Subject Sanctuary Pointe No. 10 – Construction Documents Review

Attention Debbie Flynn – Planner, Town of Monument

Date August 12, 2021

1. "Sanctuary Pointe Filing No. 10 Construction Plan Set" from Classic Consulting Engineers and Surveyors, dated June 18, 2021.
2. "Drainage Letter for Sanctuary Pointe – Church Site" from Classic Consulting Engineers and Surveyors, dated February 23, 2021.

SANCTUARY POINTE FILING NO. 10
CONSTRUCTION PLANS
STREET IMPROVEMENT PLANS
TREETOP GLORY COURT

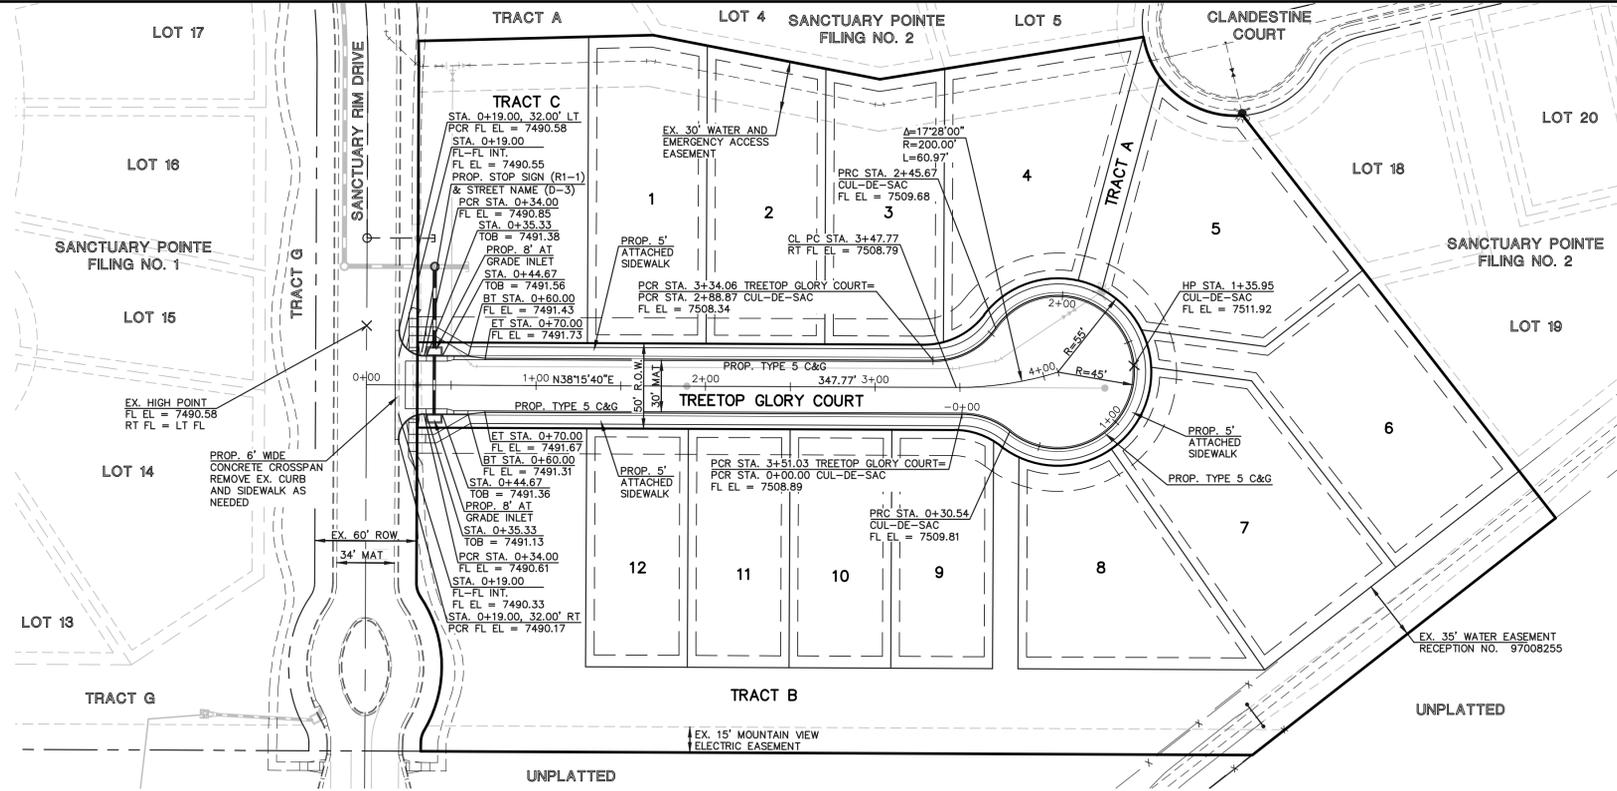
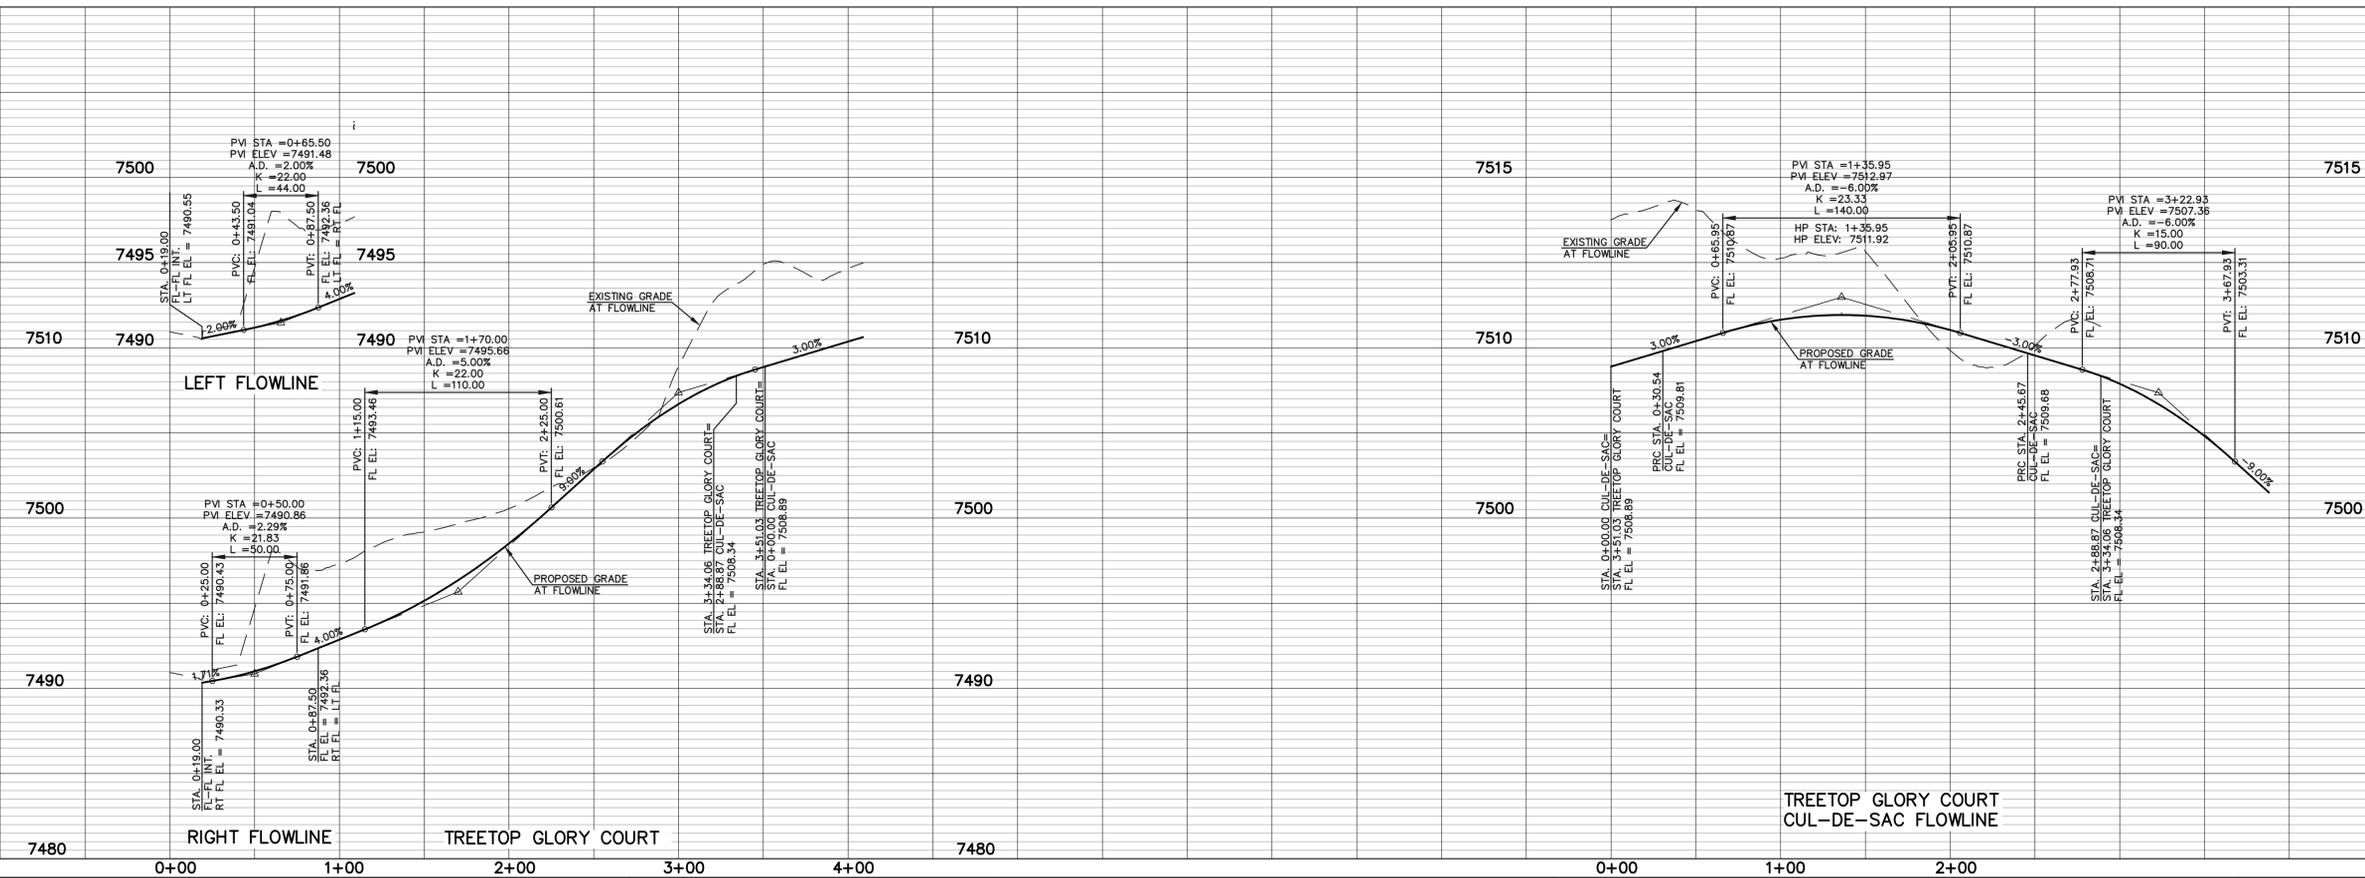
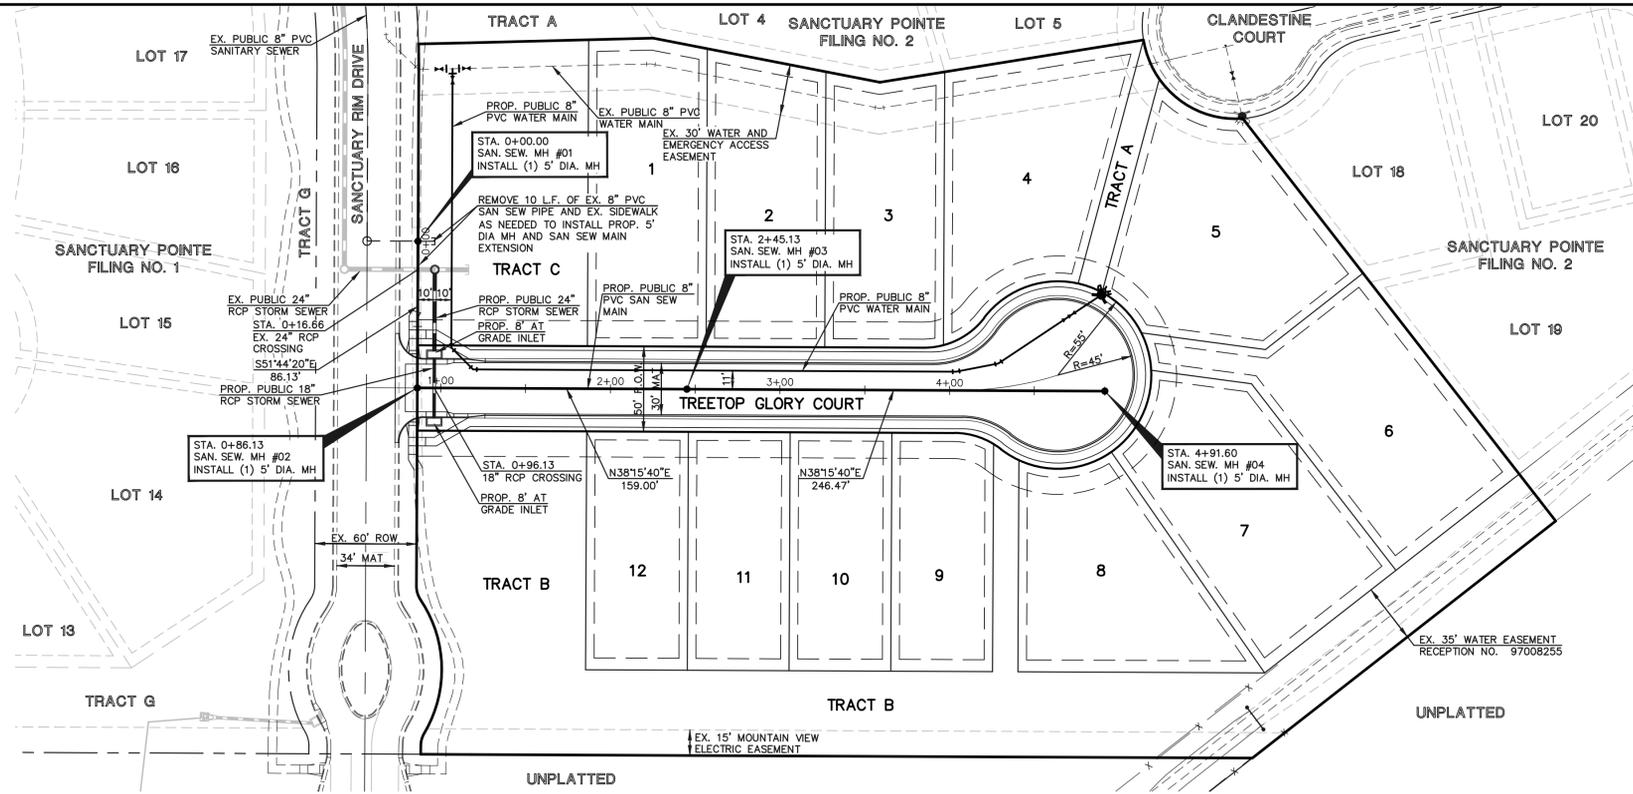
- Add location of NO OUTLET sign to plans. (see next comment) **Added**
- Recommend using DEAD END (W14-1) instead of NO OUTLET per the option in MUTCD Section 2C.26 on Treetop Glory Court. **Design remains consistent with all previous Filings**

- Given the length of the Treetop Glory Court lettering, would using W14-2a (or W14-1a) instead of a combination sign be better? I didn't lay out the SNS to determine exact length, so this comment is more food for thought. May depend on sign post type and other factors. **Noted**

- The note pertaining to sign font size should read "ALL INTERNAL STREET NAME SIGNS". **Revised**
- No radius callouts identified for curb returns these should meet 30' minimum radius identified in town standards **Curb return info added and remain consistent with all previous Filings**

- Possibly a curb and gutter type transition near inlets on both sides at station 0+70.00 if so call out what type of curb and gutter to transition to. **Added**

- No pavement section called out for Treetop Glory Court pavement will need to be designed to meet town requirements. **Noted**

SANCTUARY POINT FILING NO. 10
 CONSTRUCTION PLANS
 PUBLIC SANITARY SEWER PLAN

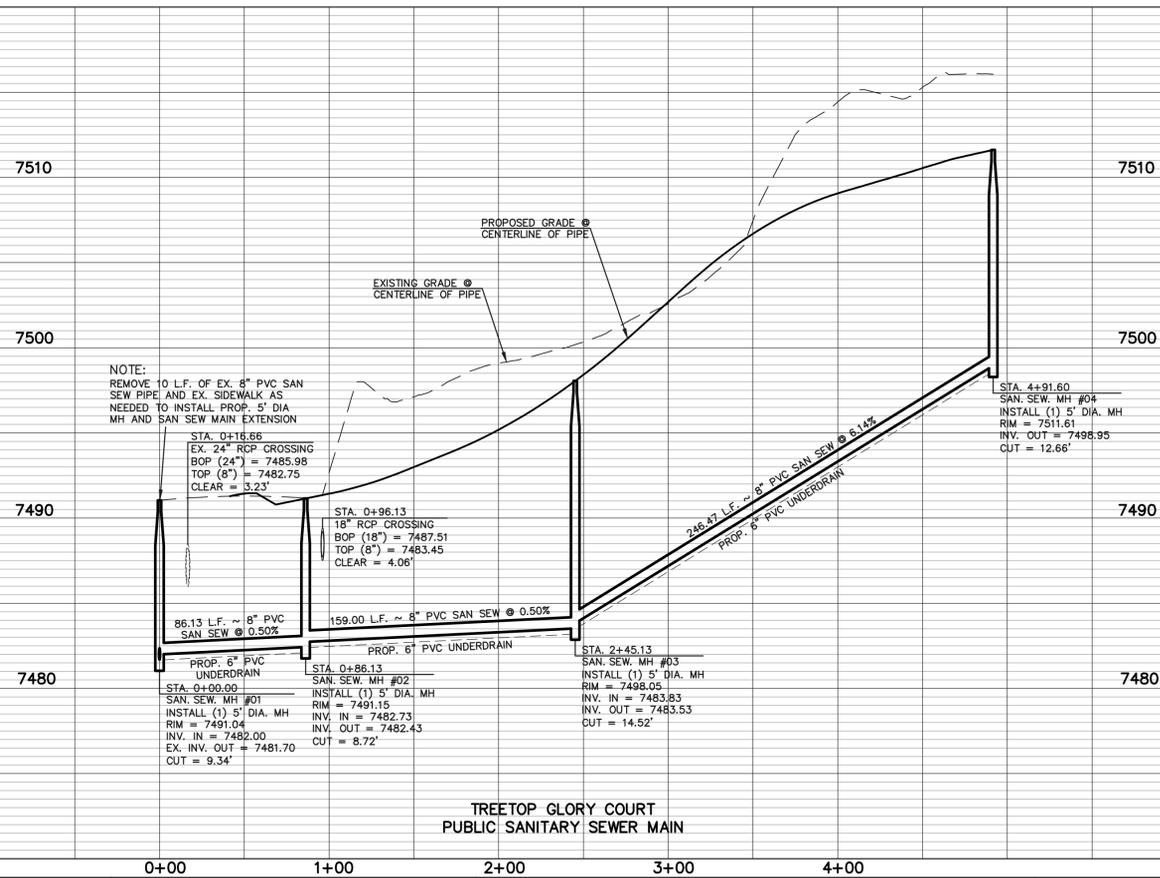
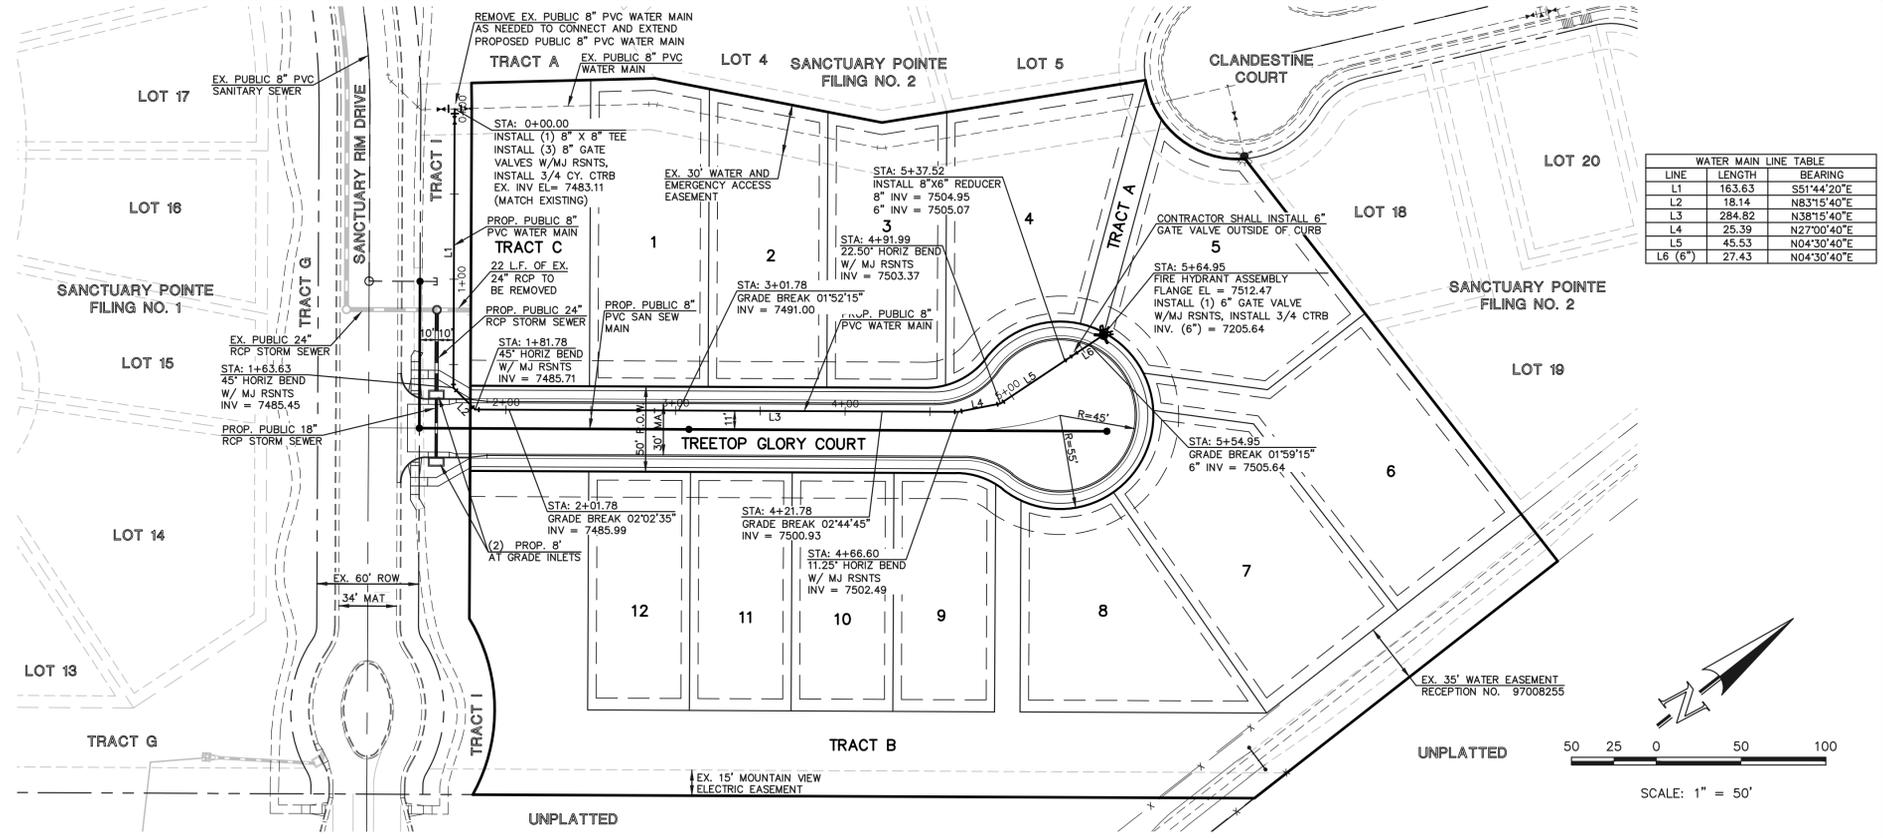
- Consider changing line types of proposed sanitary sewer and proposed water line types. **Noted**
- Show where water service line crosses sewer main (in the cul de sac) in the profile. **All service lines shown on service plan**

SANCTUARY POINT FILING NO. 10 CONSTRUCTION PLANS PUBLIC WATER SYSTEM PLAN & UTILITY SERVICE PLAN			
DESIGNED BY	PRA	SCALE	DATE 6/18/21
DRAWN BY	PRA	(H) 1" = 50'	SHEET 7 OF 9
CHECKED BY	(V) 1" = 5'	JOB NO.	1100.61

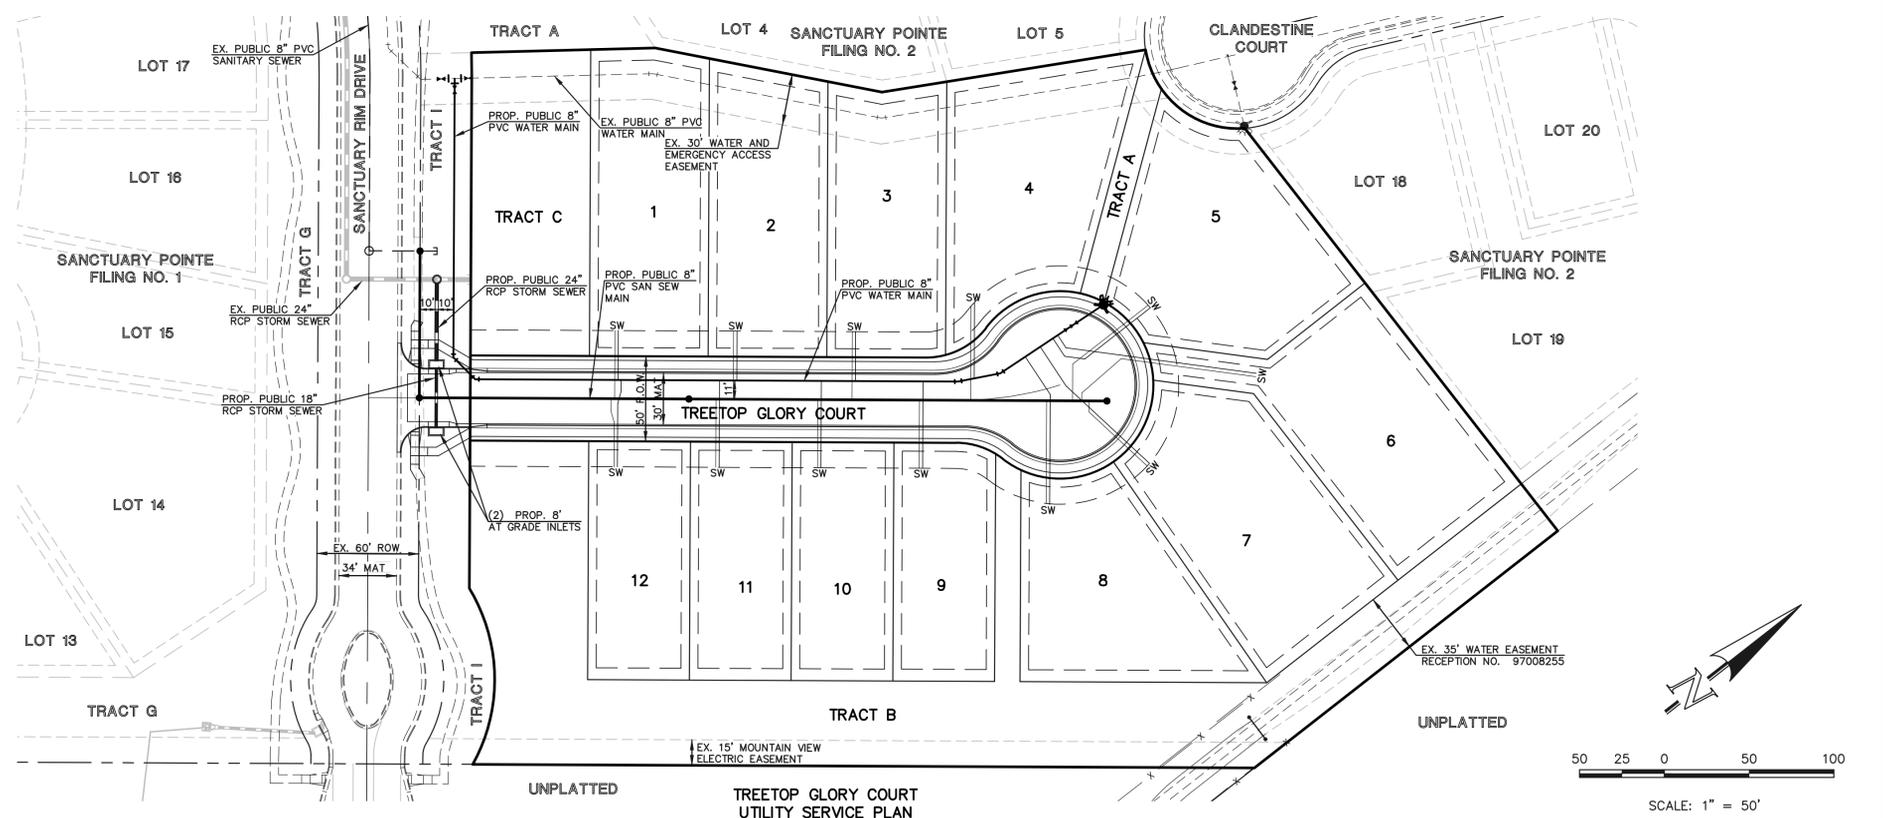
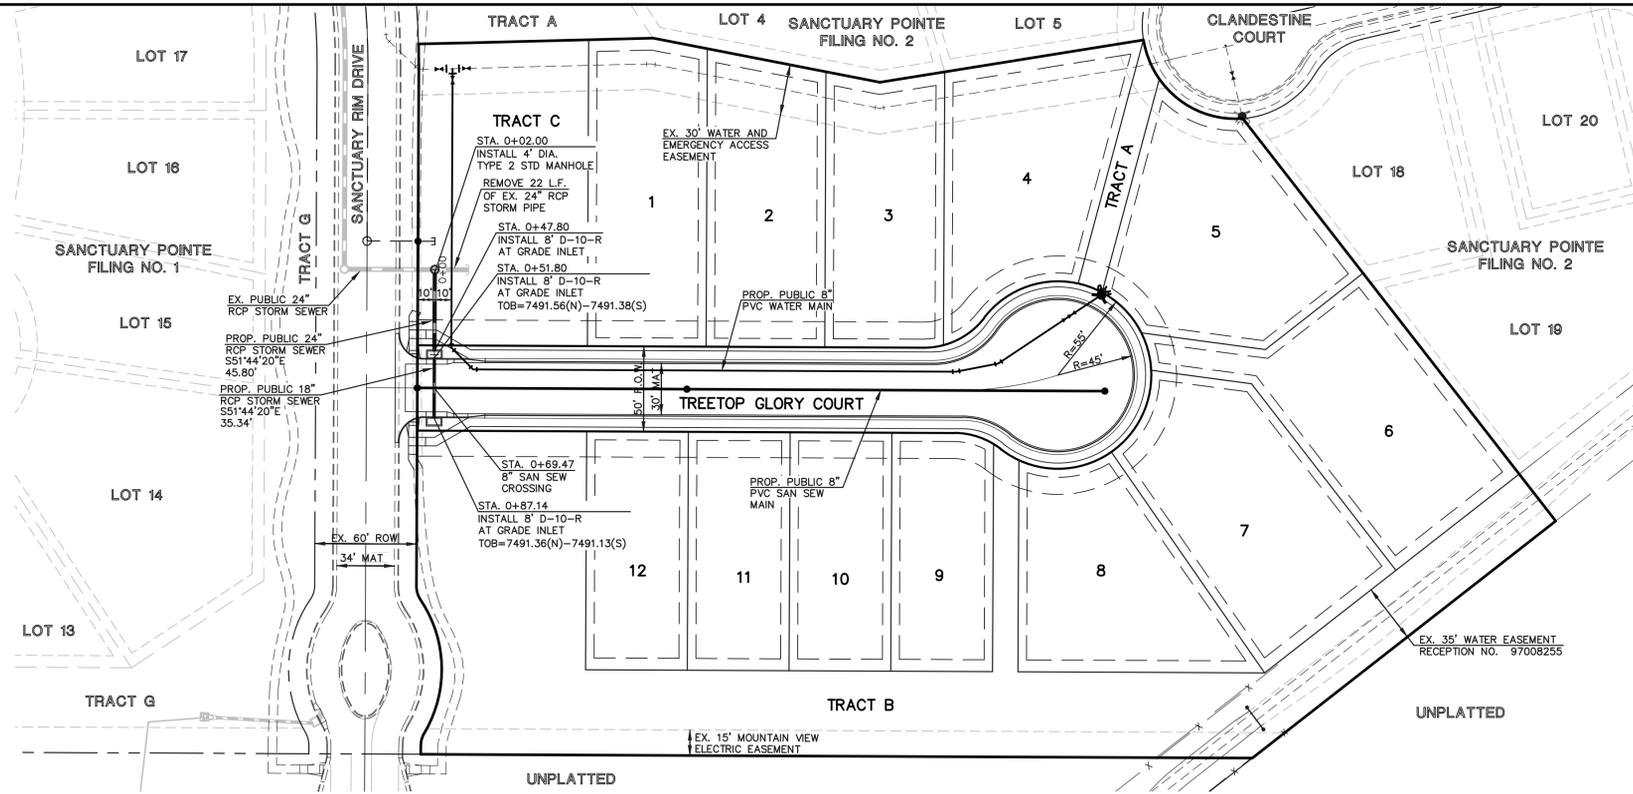
- Add another fire hydrant – maximum spacing of fire hydrants should be 500 feet in residential areas. **Added**
- Label above treetop glory court (STA: 3+01.78) is partially blocking another label (Prop. Public 8") **Adjusted**
